**Consultation Response from KC,
Highways Development Management**

**2023/93742 land adj The White House development, Chain Road, Slaithwaite, Huddersfield, HD7
5TY**

Erection of 2 detached dwellings

Date Responded: 16-4-2024.

Block Plan showing proposed levels
1 : 500

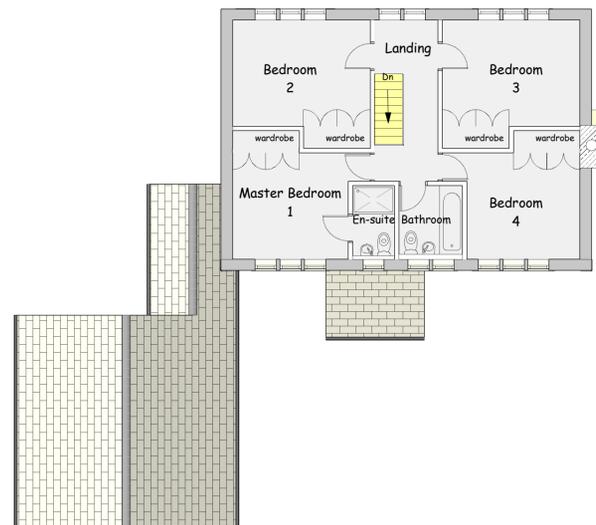
1, No details of the sight lines from the proposed new access onto Chain Road are provided. The speed limit along Chain Road is 60 mph. HDM would recommend that speed surveys are undertaken, and the applicants are asked to demonstrate that their proposed sight lines are satisfactory for the 85-percentile speed of vehicles along this section of Chain Road.

2, No details of bin collection points are provided. Bin collection points should be provided to both dwellings to enable bins to be presented on collection day without either obstructing the highway or proposed driveway.
